**PRELIMINARY PLOT PLAN**

FOR  
 CAPITOL CITY HOMES  
 162 SPRUCE HOLLOW CIRCLE  
 LOT 1152 ANDERSON CREEK CROSSING SUBDIVISION; PHS 7  
 ANDERSON CREEK TWP., HARNETT CO., NC  
 P.B. 2018, PG. 229

Carriage Circle 1152 - 162 Spruce Hollow Circle, Spring Lake 28390  
 Harnett County  
 Watson II C  
 Left Slab

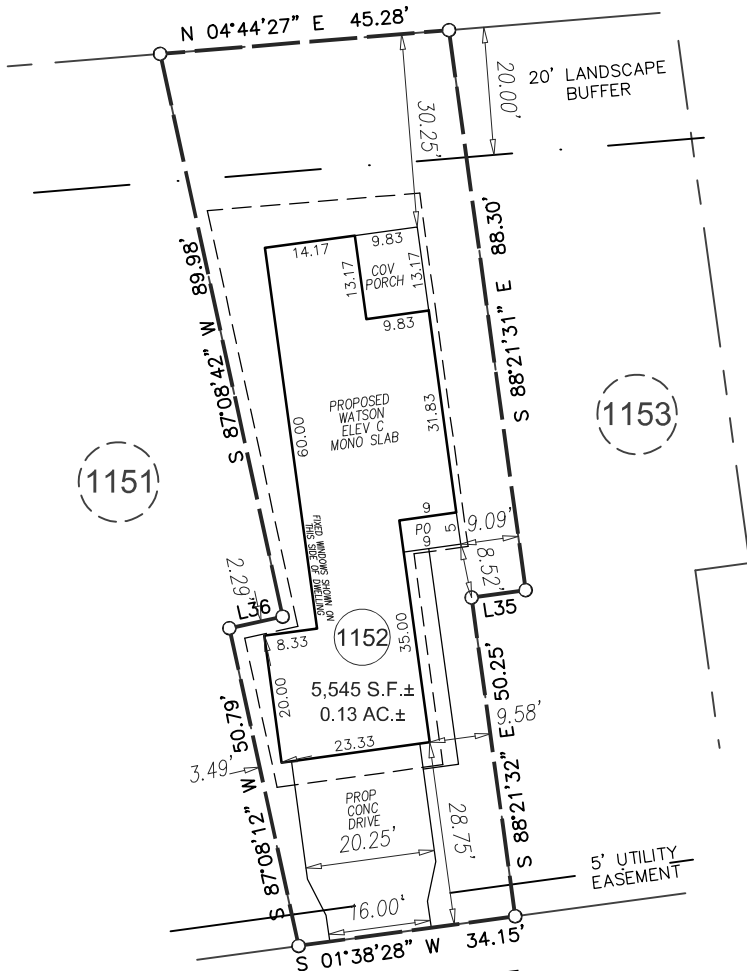
1 Hr rated  
 Construction required
